RE: Goodwill Bluewater – Erosion & Sediment Control Plan

Below are my responses to the Erosion & Sediment Control Plan Review dated October 18, 2024.

**RE: Goodwill at 270 98<sup>th</sup> St NW  
Erosion and Sediment Control Plan  
Engineer's Stamp Date 9/13/24 (K09E048E)**

| Sheet No.: C-6.0            |                 |

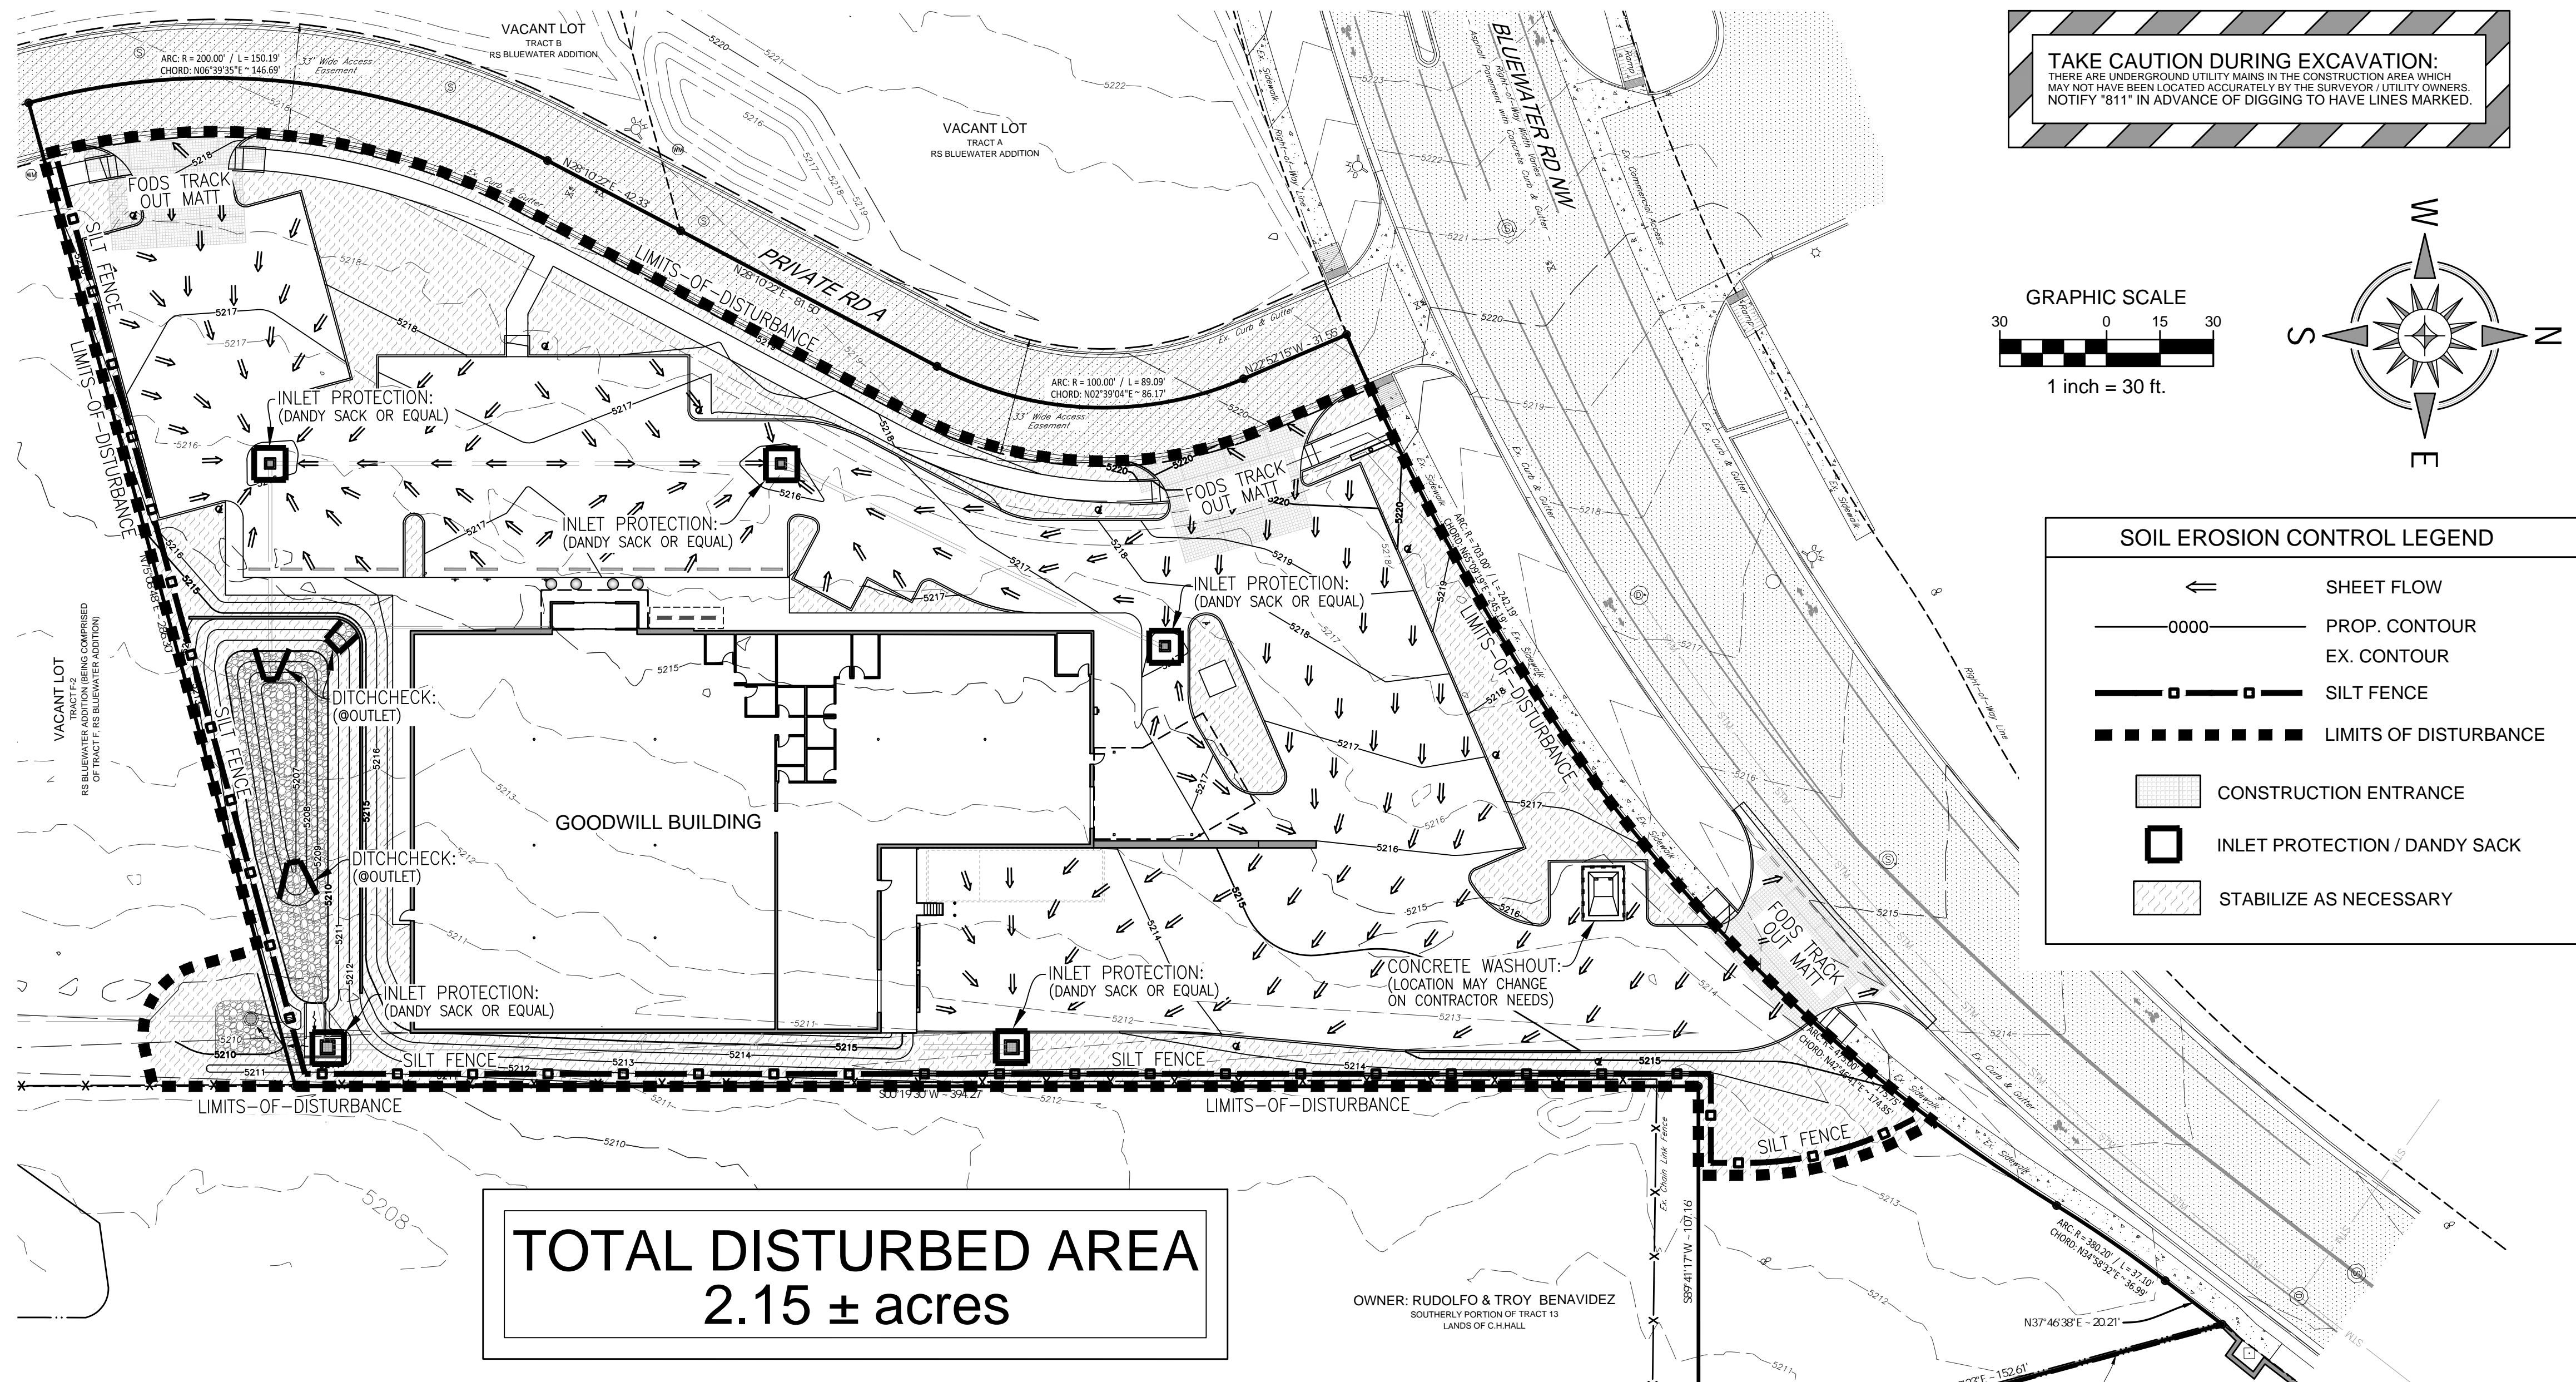
1. This site's only allowed stormwater discharge location is concentrated flow from the southeast corner. Silt Fence (SF) isn't adequate for concentrated flow, so you must provide diversion berms/swales (DV) along the low edges of the site to direct stormwater into a Sediment Basin (SB) or Sediment Trap (ST) per CGP 2.2.12 in addition to the SF.

- a. Design the basin or impoundment to provide storage for either:
    - i. The calculated volume of runoff from a 2-year, 24-hour storm or
    - ii. 3,600 cubic feet per acre drained.

- b. Utilize outlet structures that withdraw water from the surface of the sediment basin or similar impoundment unless infeasible.
  - c. Use erosion controls and velocity dissipation devices to prevent erosion at inlets and outlets.

- e. Specific location of the basin, including dimensions.
- f. Plan view of the storage basin and emergency spillway, showing existing and proposed contours.

- g. Add a bold note at the pond saying, "the pond may not be removed until the rest of the construction is complete and the site is stabilized."
- h. Cross section of dam, principal spillway, emergency spillway, and profile of emergency spillway with elevation specifications for each.

1. Sheet C-6.1 now shows the concentrated stormwater at the Southeast corner of the site being collected with an inlet where it will discharge into the approved sediment control basin for the site per the approved grading plan dated 4/18/22 (K09D048). The existing ditch line and berm along the east property line is noted to be maintained throughout construction until the permanent underground storm piping and SWQ basin are installed (details on sheet C-6.0).

2. Details for the existing approved Sediment basin can be found on the "Construction Plans for 98<sup>th</sup>/Bluewater Commercial Development Public Infrastructure"

C-6.0

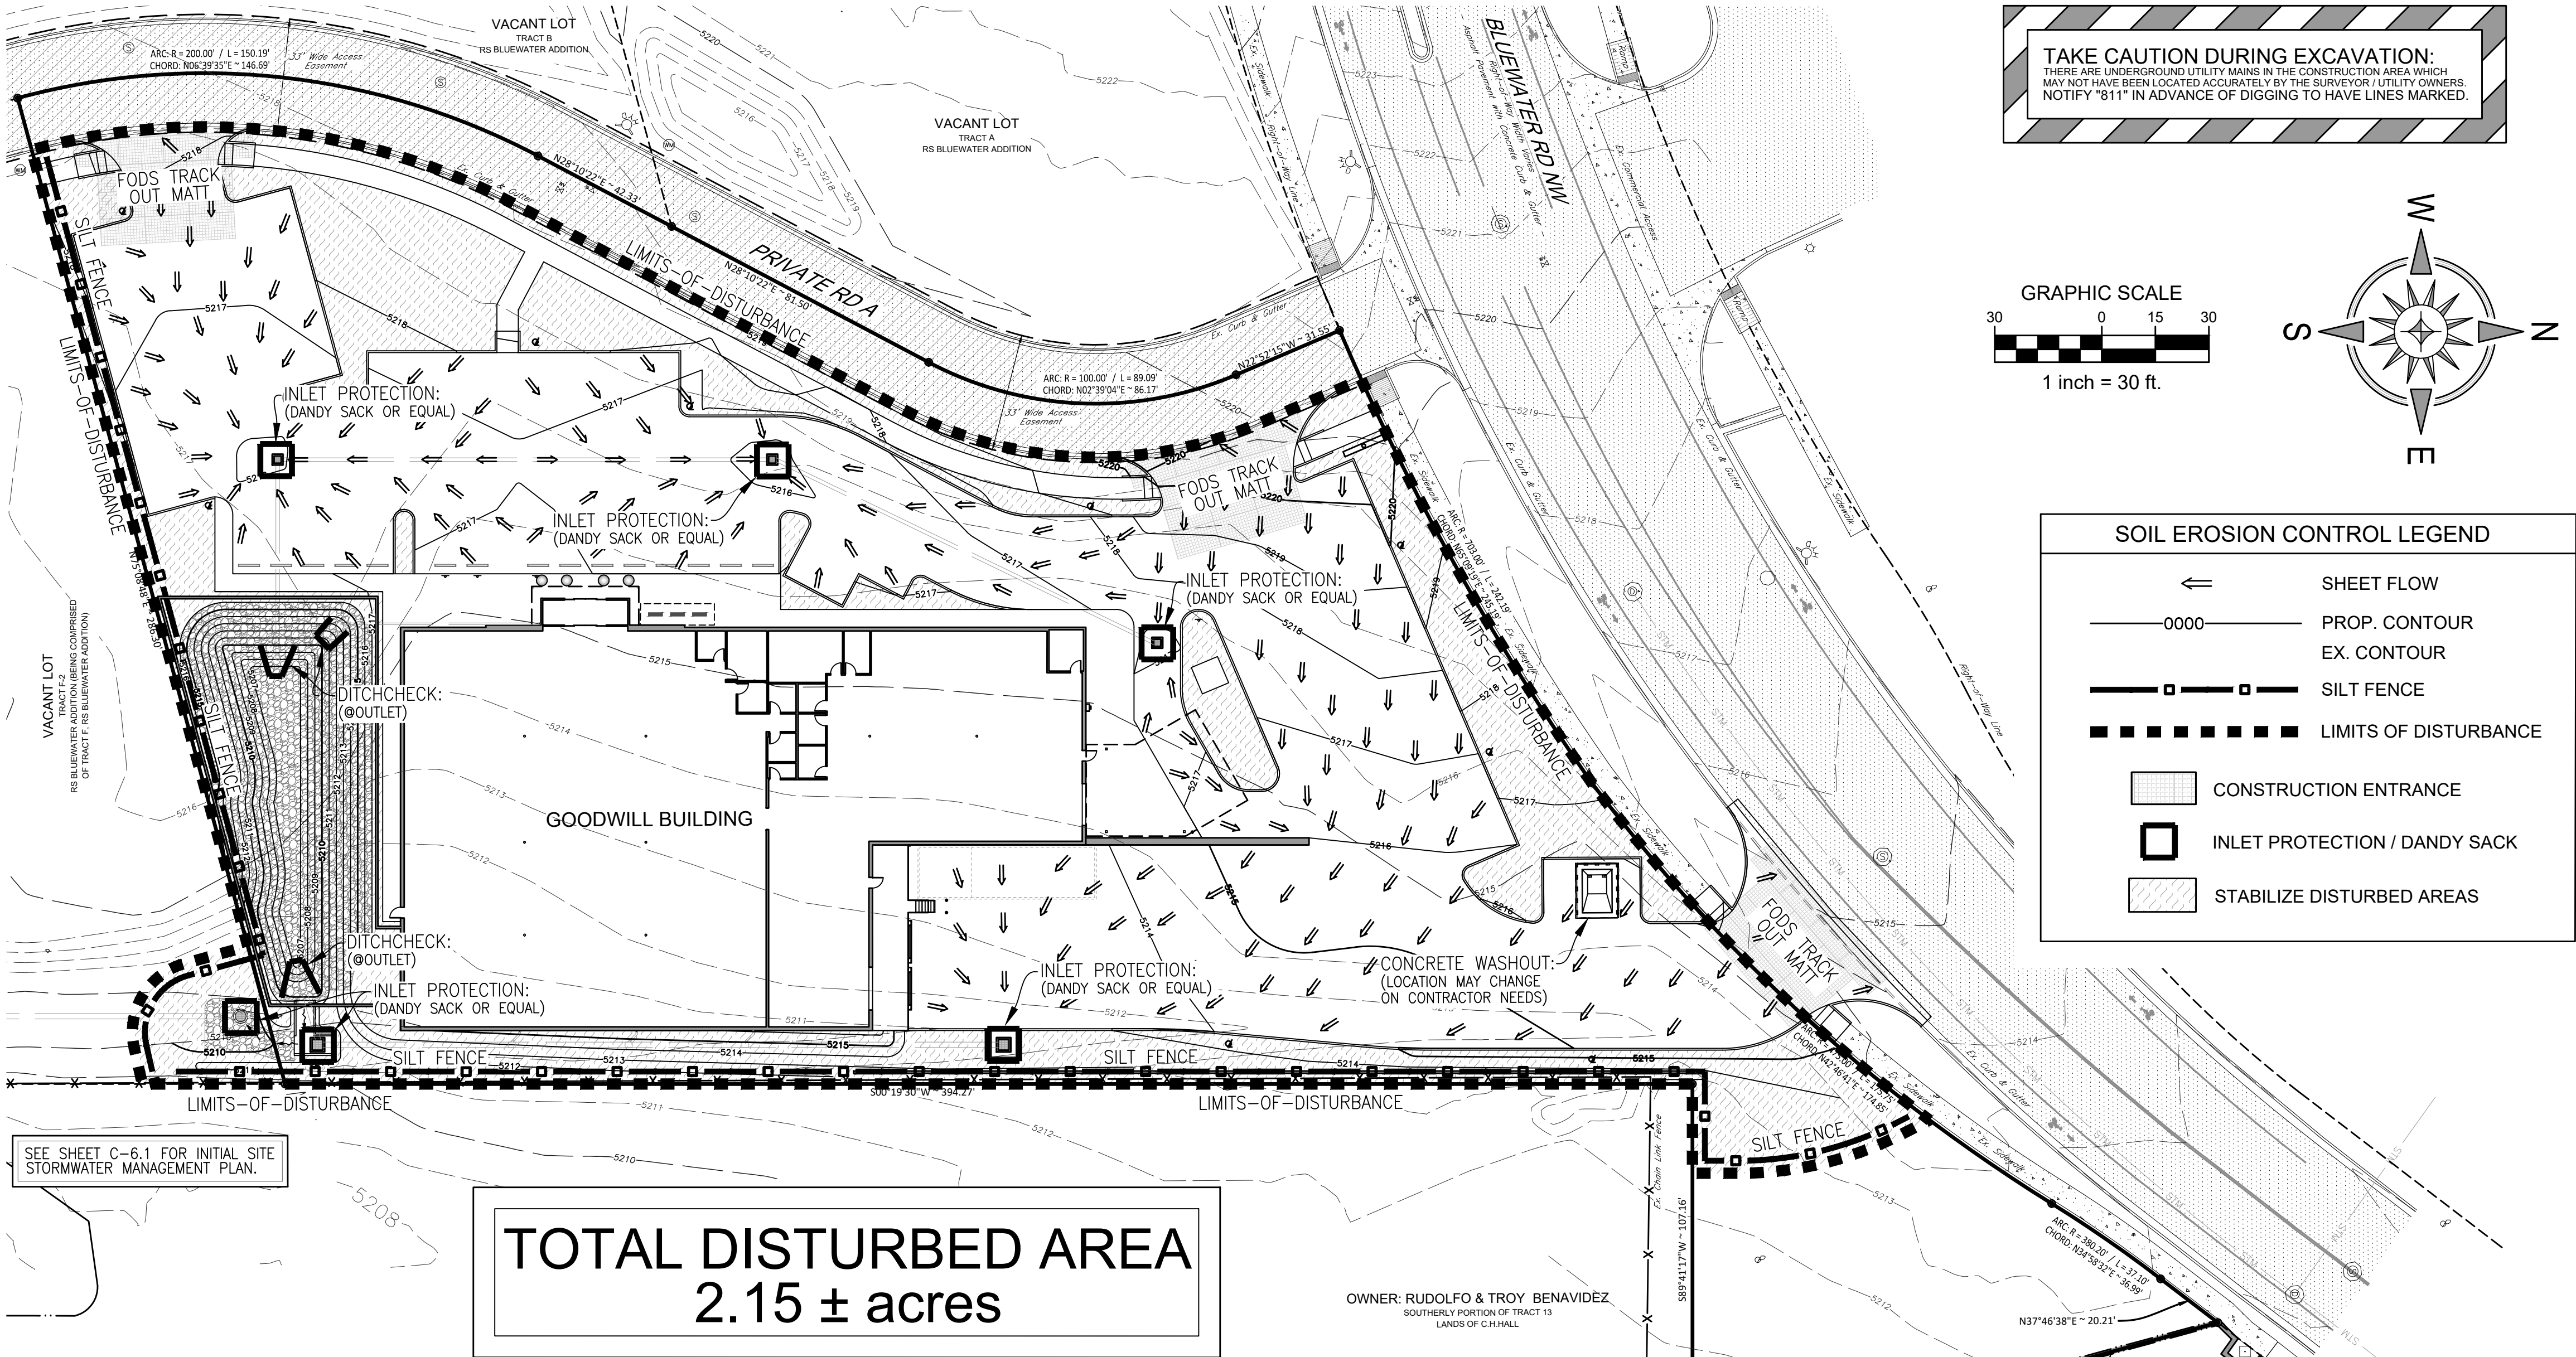
2. Construction details and specifications for DV, SB, and ST are missing and must be added to the Detail sheet per CGP 9.6.1.c.i.
3. The SWPPP must include site-specific interim and permanent stabilization per CGP 9.6.1.c.i. The Landscape Plan can be used to satisfy this requirement and should be submitted separate from the ESC Plan with the application to the Stormwater Quality Section of the Planning Department and they should be included in the SWPPP. Provide specifications on the ESC Plan for any disturbed areas not covered by the Landscape Plan.
4. Replace the City Standard Notes with the current version (attached).
5. Update the engineer's stamp date each time the plan changes.

3. Notes 6 & 9 under General stormwater notes on sheet C-6.0 state what the contractor shall do after rough grading and areas that are disturbed. The legend shows what areas the contractor will need to stabilize after final construction, and it is noted that any disturbed area that remains idle longer than 21 days will need seeded and mulched, which takes care of temporary construction on the site.

4. Notes have been replaced with the newly provided set.
  5. Stamp date has been updated.
- Please see attached Erosion & Sediment Control Plan.
